**re: Geotechnical Response to City Comments  
Proposed Industrial Redevelopment  
135 Cardevco Road – Carp - Ontario**

**date: June 6, 2023**

**file: PG6018-MEMO.01 Revision 1**

STORMWATER DETENTION RETAINING WALL DETAILS

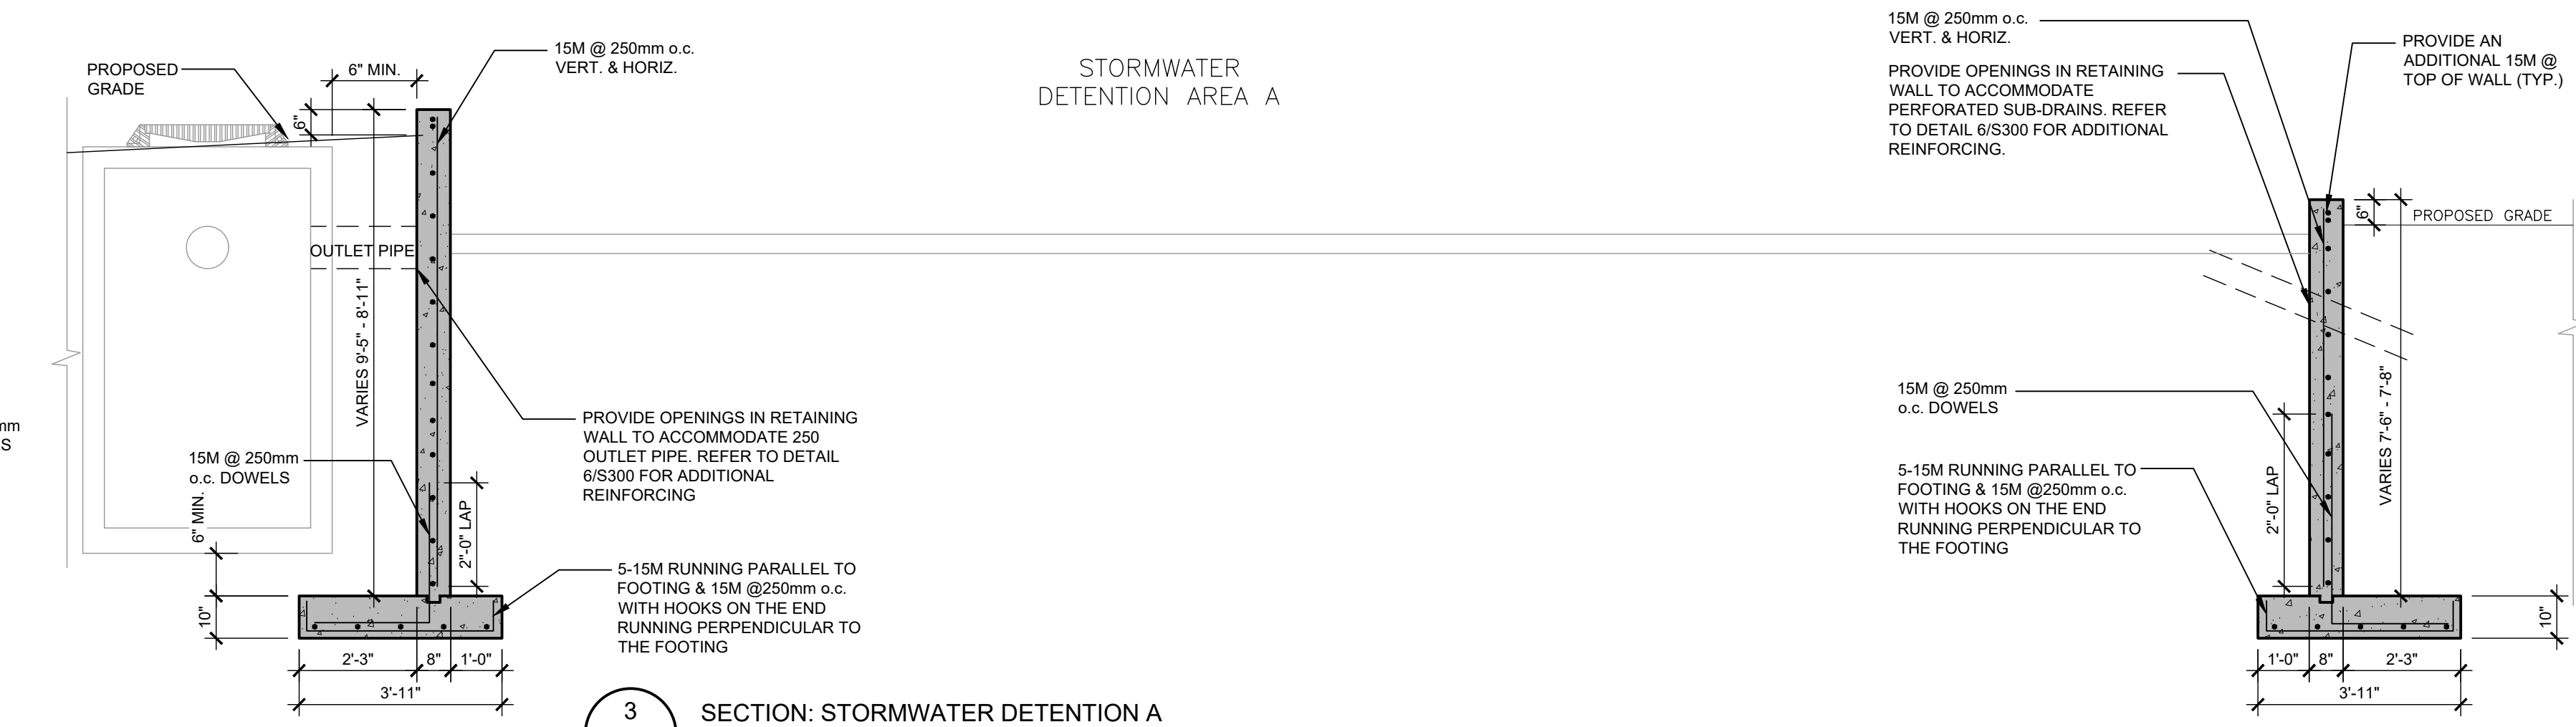
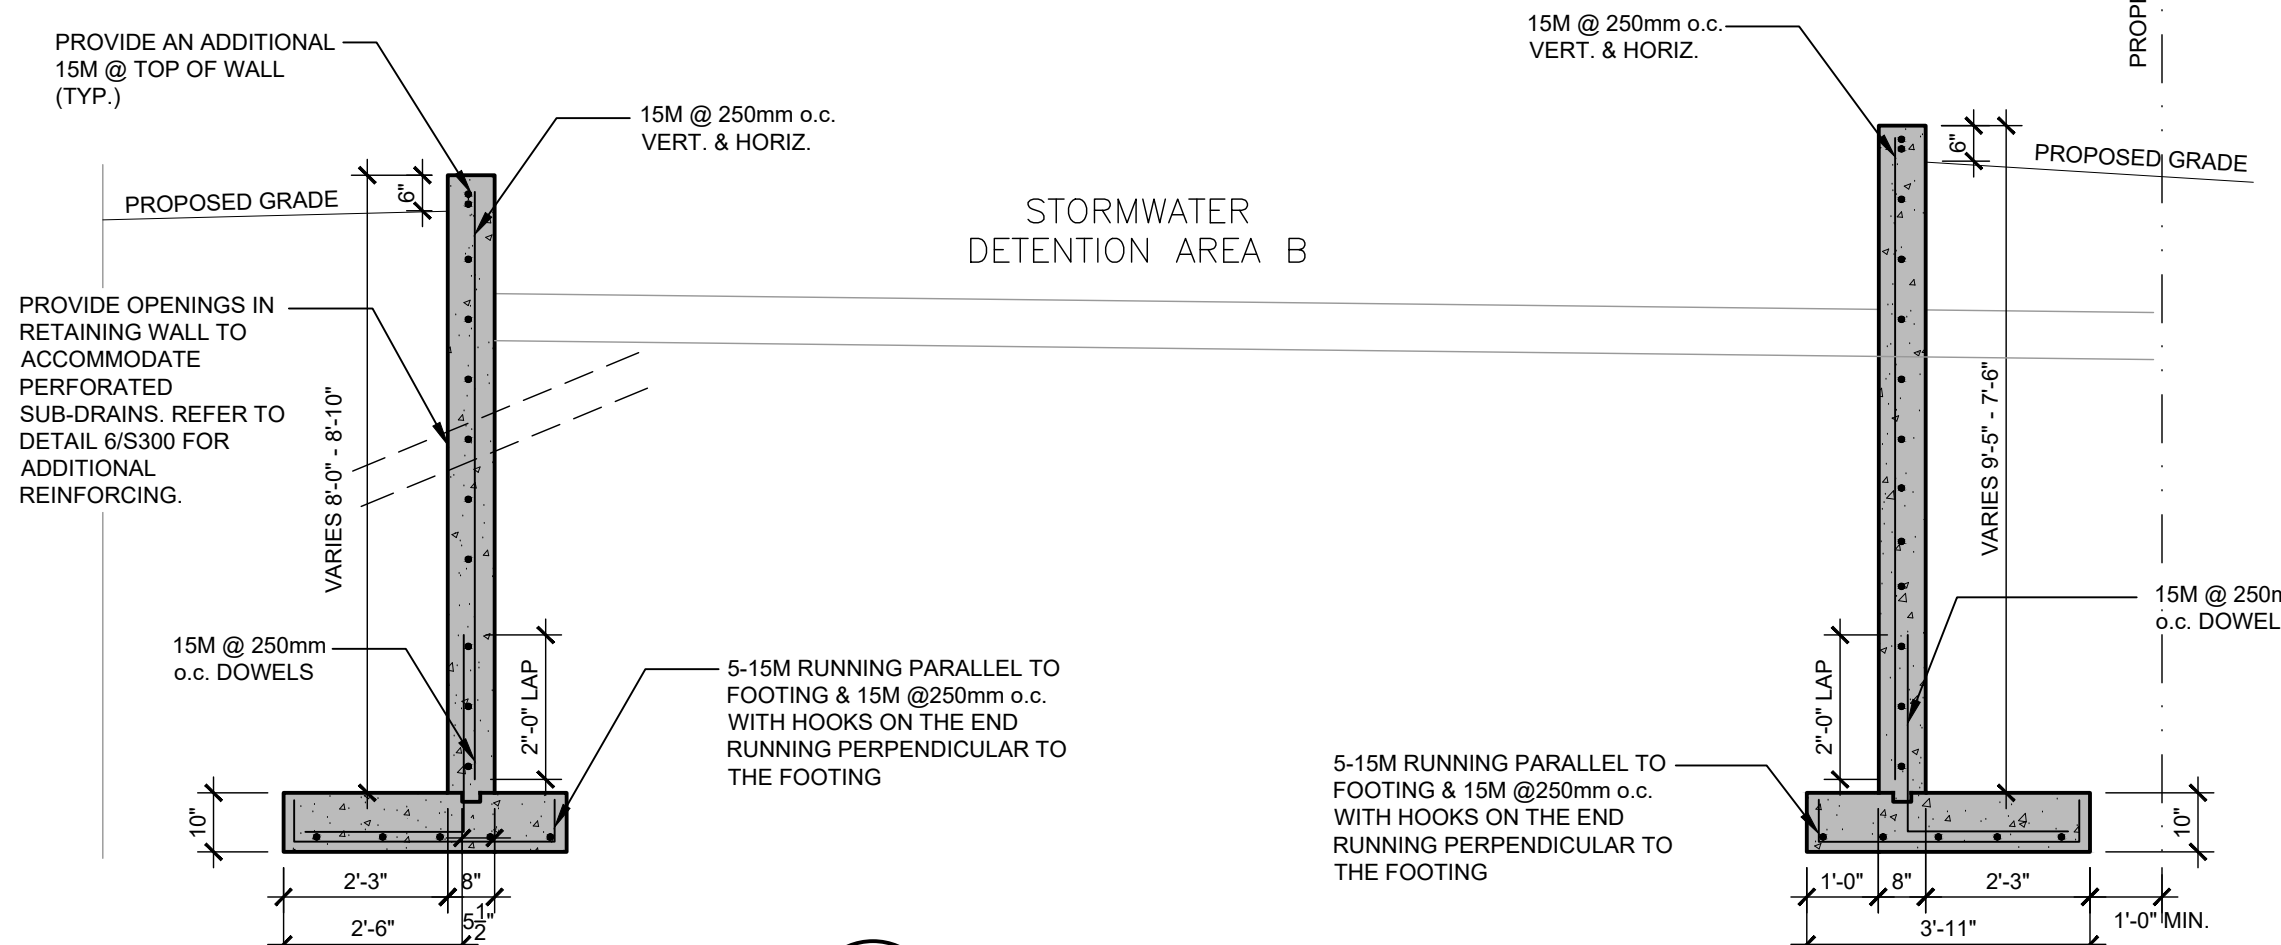
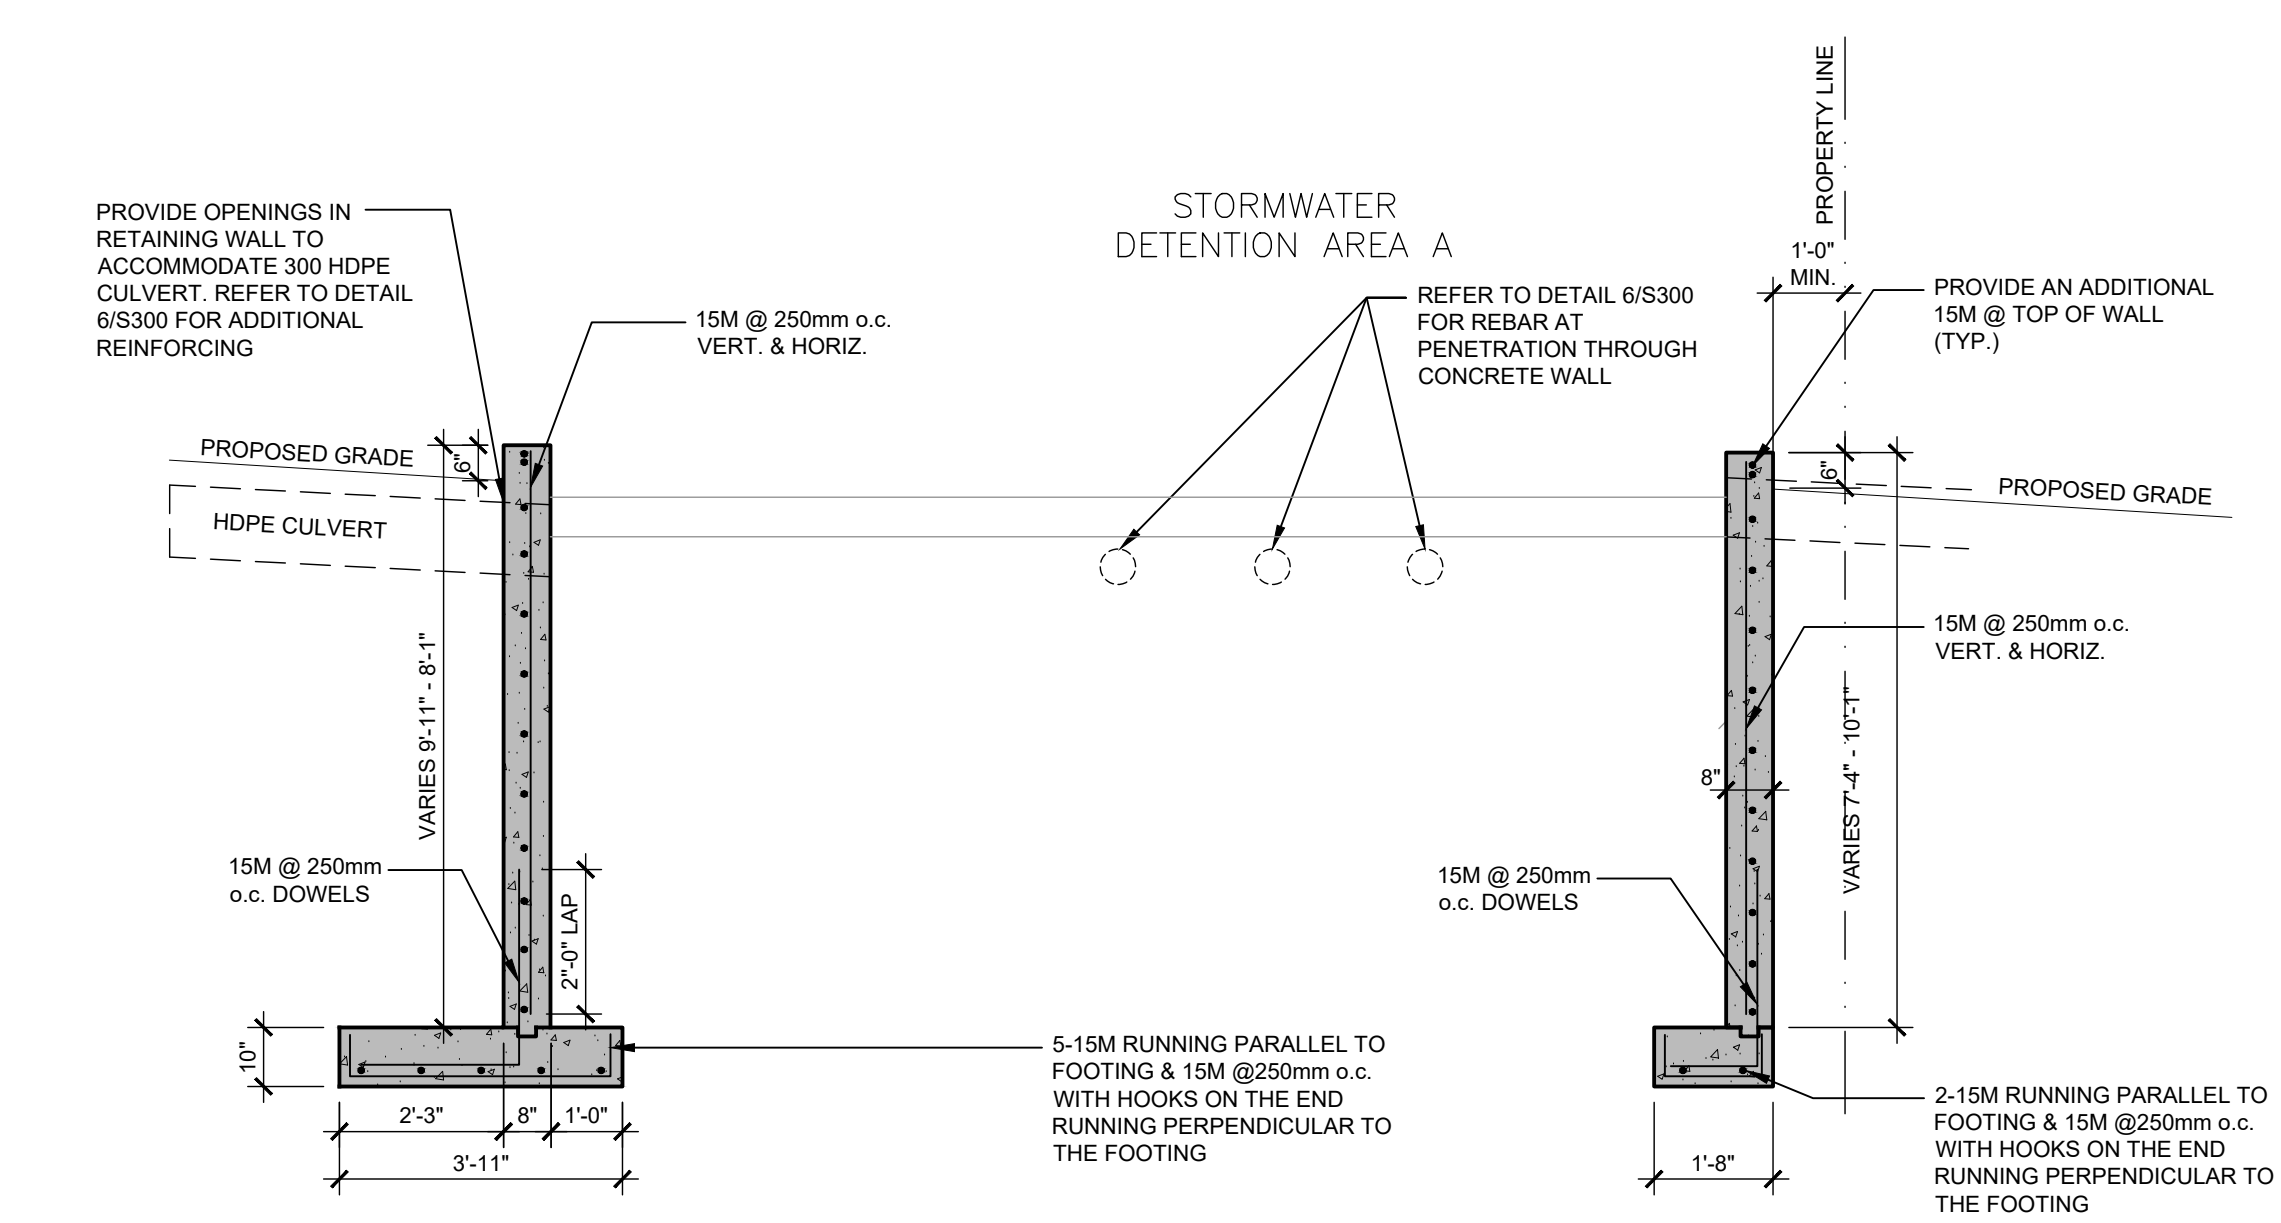
*There are proposed retaining walls on site, however no retaining walls/geotechnical considerations are provided in the report; please also investigate if slope stability considerations apply.*

It is understood that the design of retaining walls will be done by others and is outside the scope of the geotechnical report. However, Paterson can provide a design for retaining walls if requested. For slope stability analysis, the ground surface at the subject site is generally flat and slopes gently from approximate geodetic elevation 119.3 to 118.5 at the west and east sides, respectively. In addition, there is no watercourse noted within the proximity of the subject site. Therefore, no slope stability analysis is required for the subject development.
